CITY OF ALBUQUERQUE

Re: Albuquerque Studios Master Plan Development
Traffic Impact Study
Report date September 13, 2021
Engineer's Stamp 9/13/2021

The subject Traffic Impact Study received on September 13, 2021, has been reviewed by the City. The following comments are to be addressed satisfactorily before final approval by the City of Albuquerque Planning Development Transportation Section.

Figure 17 summarizes the recommendations for traffic control and lane configurations for the Implementation (Buildout) Year.

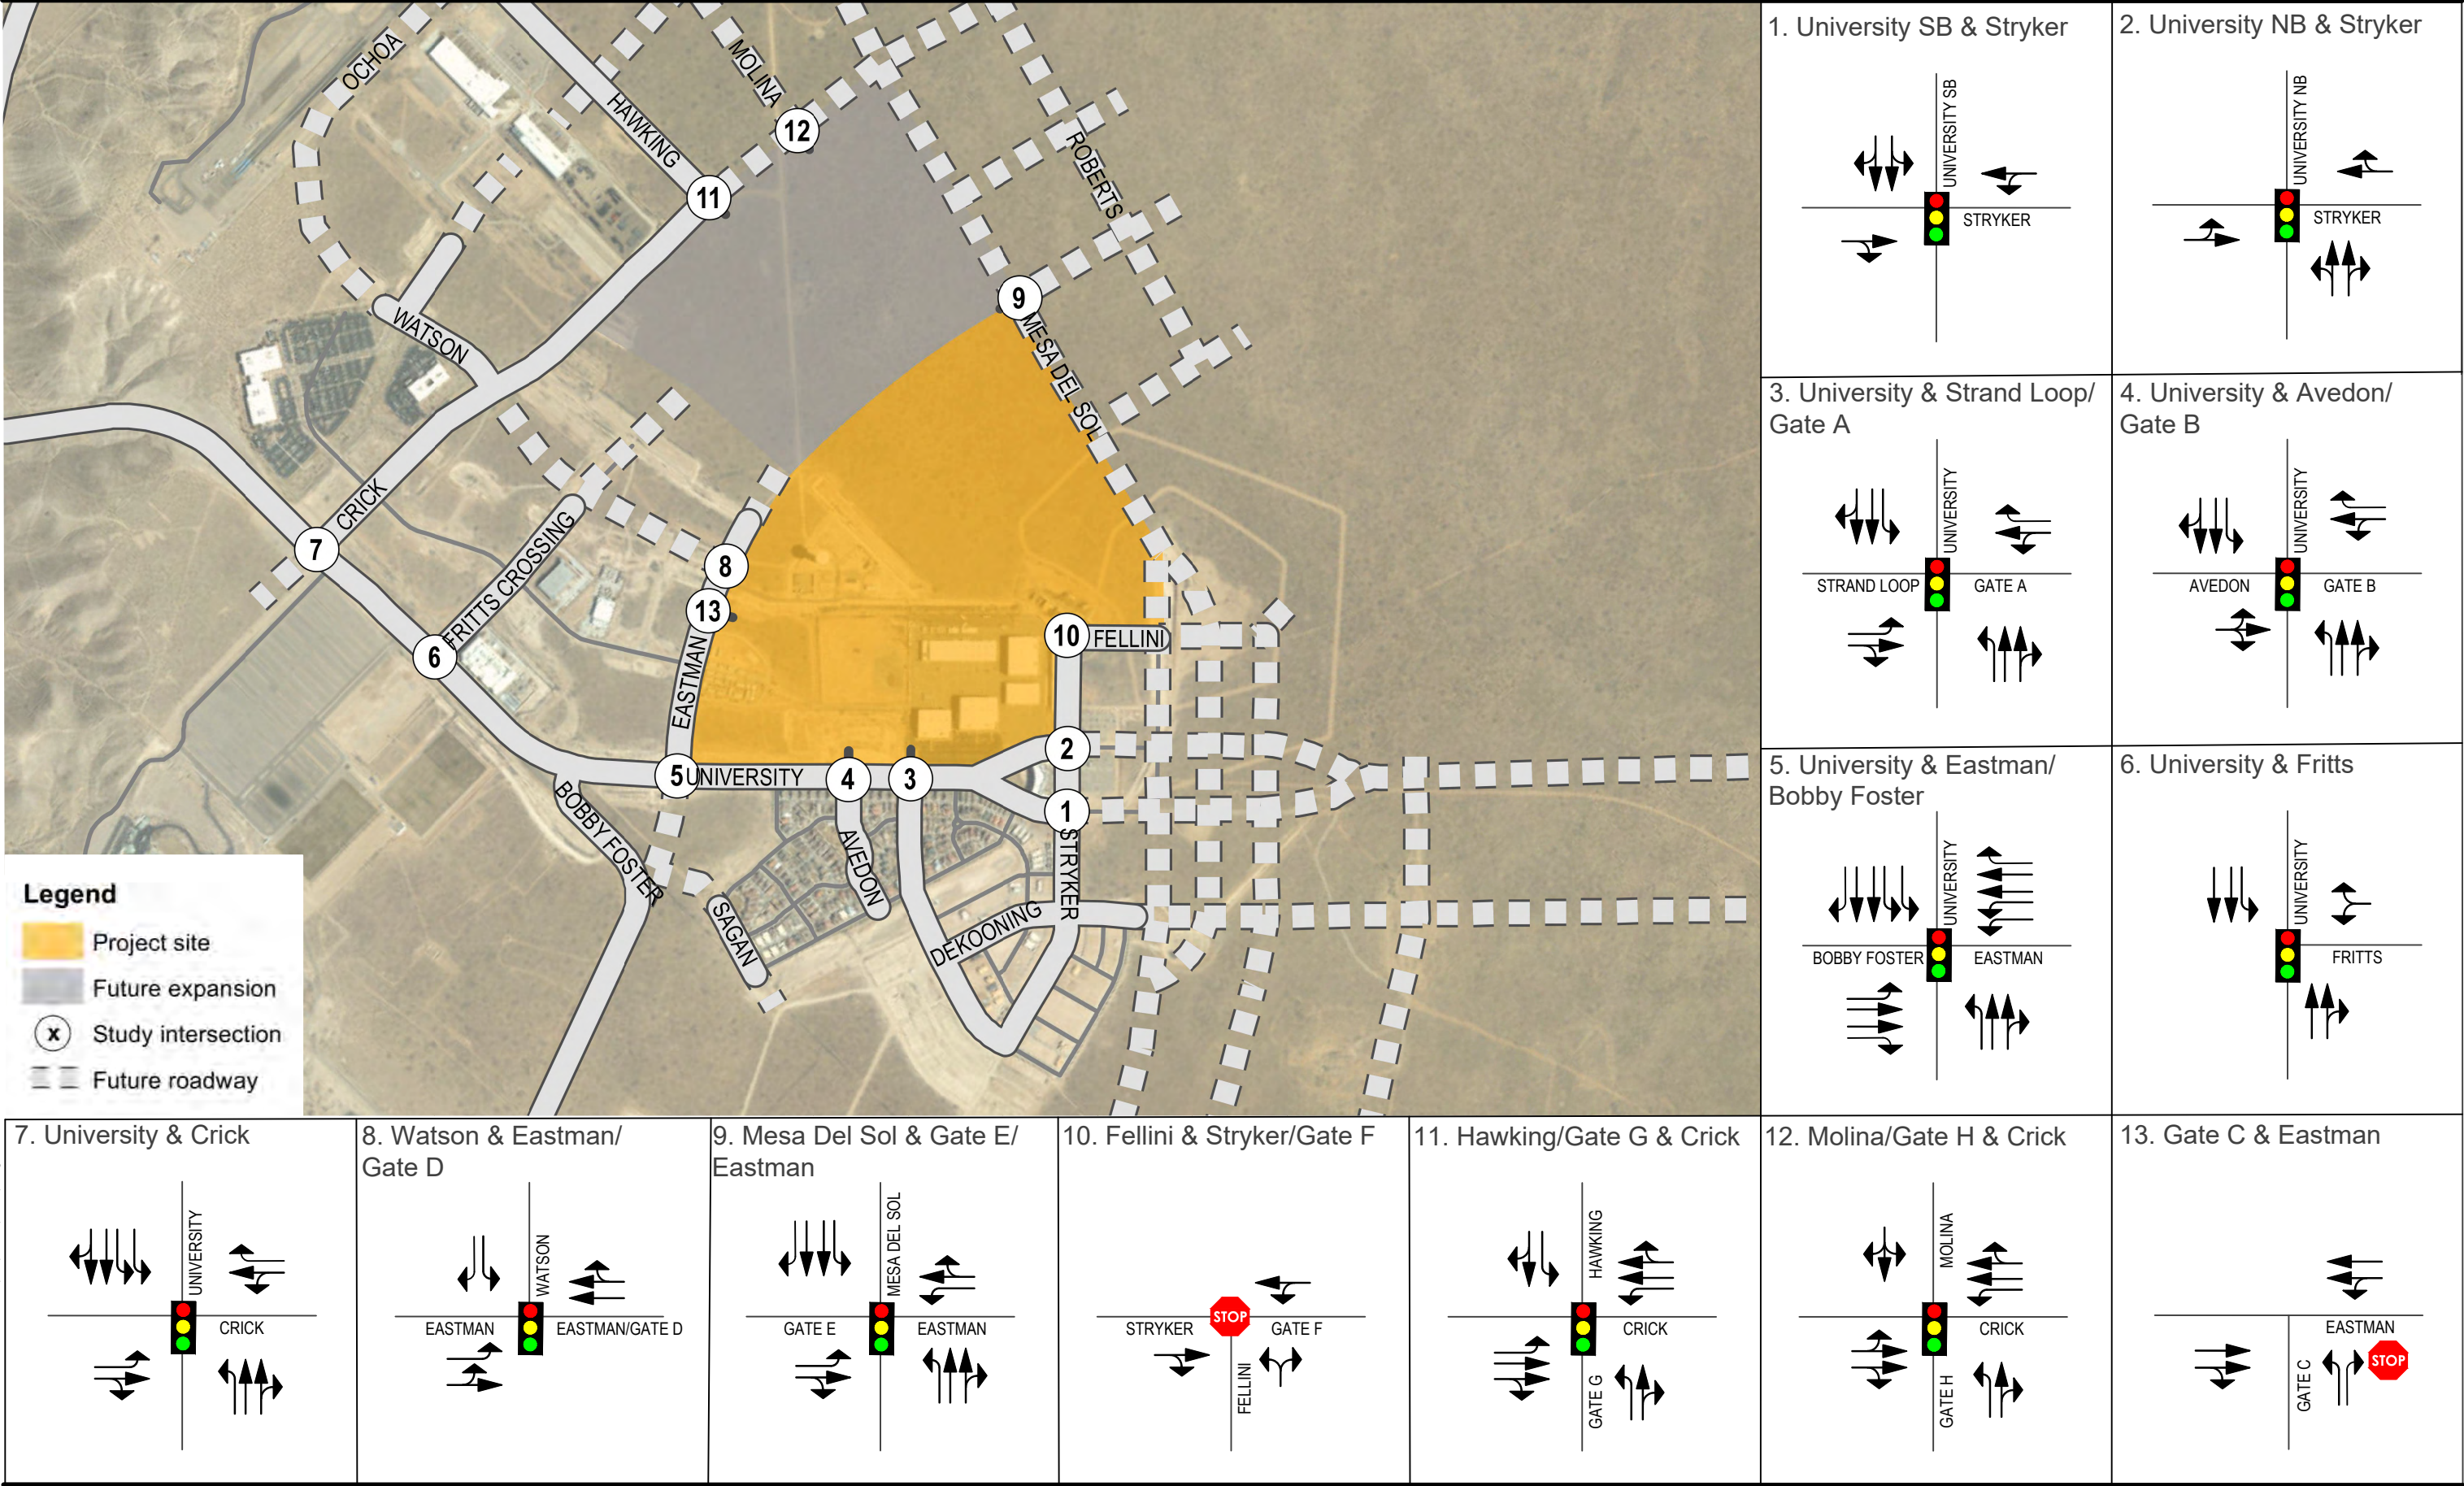
Many of the intersections on University meet warrants for right or left turn lanes. Attached to this letter are tables that show which intersection and movement meet turn lane warrants. Evaluate the locations where turn lanes are to be built for available right of way and other geometric restrictions to assure that the improvement can be built.

Intersection control for Eastman/University/Bobby Foster intersection should consider a roundabout as first choice over a traffic signal. The Montage study is investigating the use of a roundabout and the ROW required.
